CITY OF ALBUQUERQUE

Re: Raising Cane's 4800 Montgomery Blvd. NE
Traffic Impact Analysis
HT#G17D011
Engineering Seal date 4/27/2022

Review of the Raising Cane's 4800 Montgomery Blvd. NE Traffic Impact Analysis (TIA), dated 4/27/2022, received May 2, 2022 has been completed. The City's Planning Transportation Development Section has approved the report. The following improvements shall be included in the project development Infrastructure List.

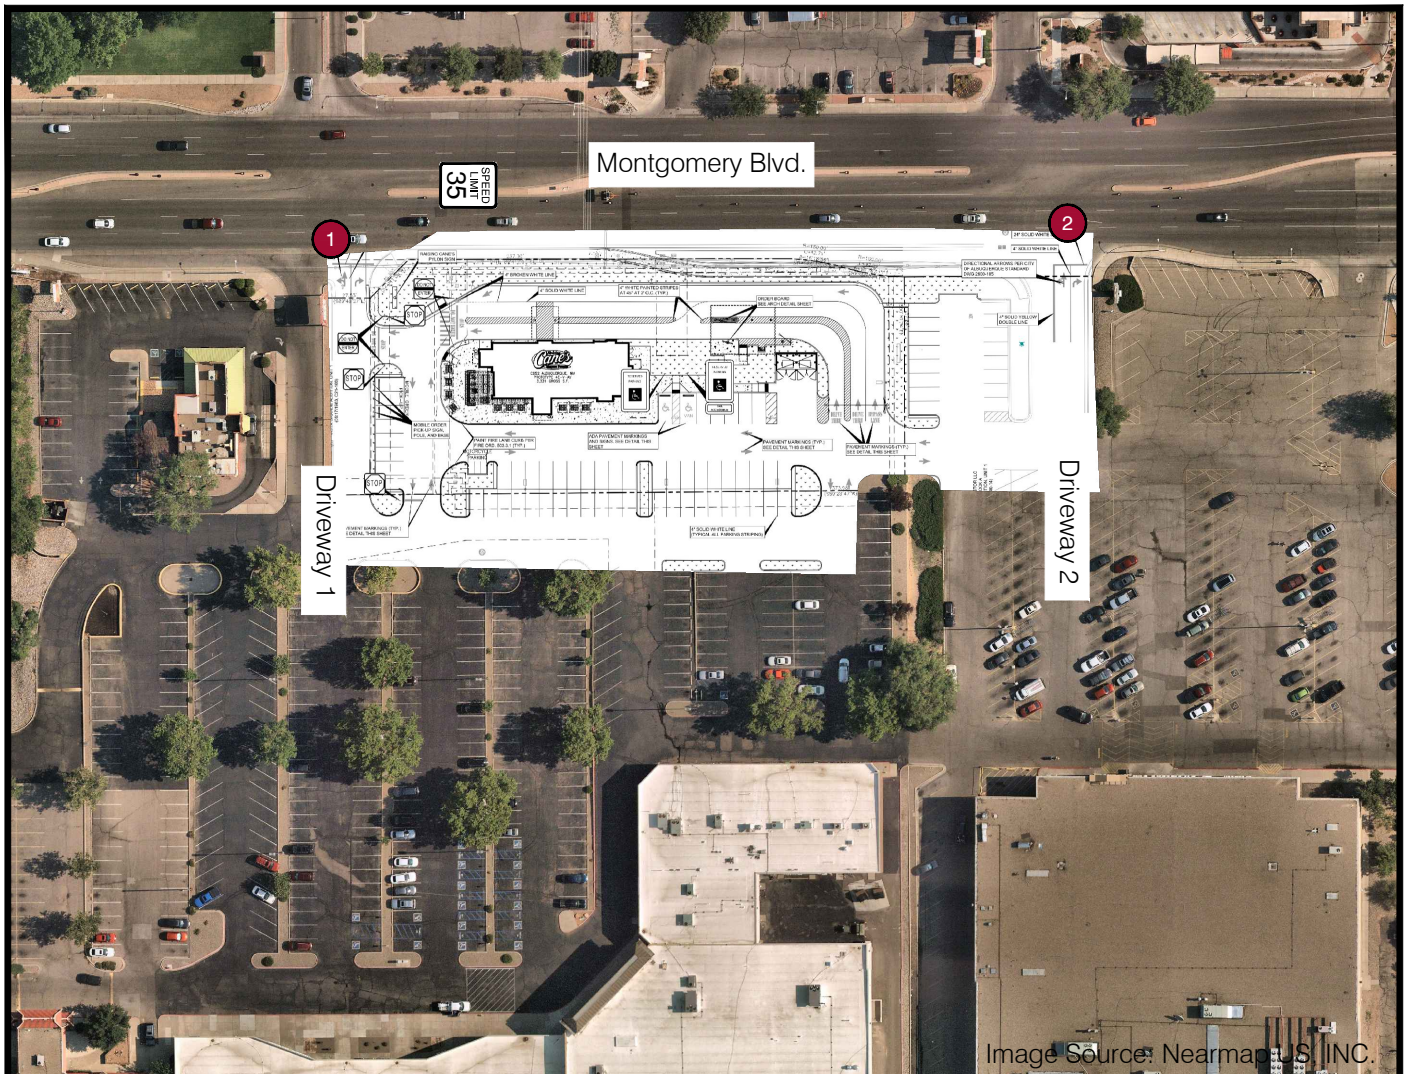
1. Driveway #1 egress should be separated into a right-turn lane and a combination left-turn/through lane. This can be accomplished by lane striping, pavement turn symbols and lane control signs.

1. Driveway #2 egress should be separated into a right-turn lane and a combination left-turn/through lane. This can be accomplished by lane striping, pavement turn symbols and lane control signs.
2. The existing eastbound right-turn lane at Driveway #2 should be lengthened. Due to the proximity of an electrical transmission tower west of driveway #2 the reconstructed turn lane length will be shorter than the recommended 250 feet plus transition. It appears that a 200 feet long plus transition turn lane can be accommodated without relocation of the utility pole.
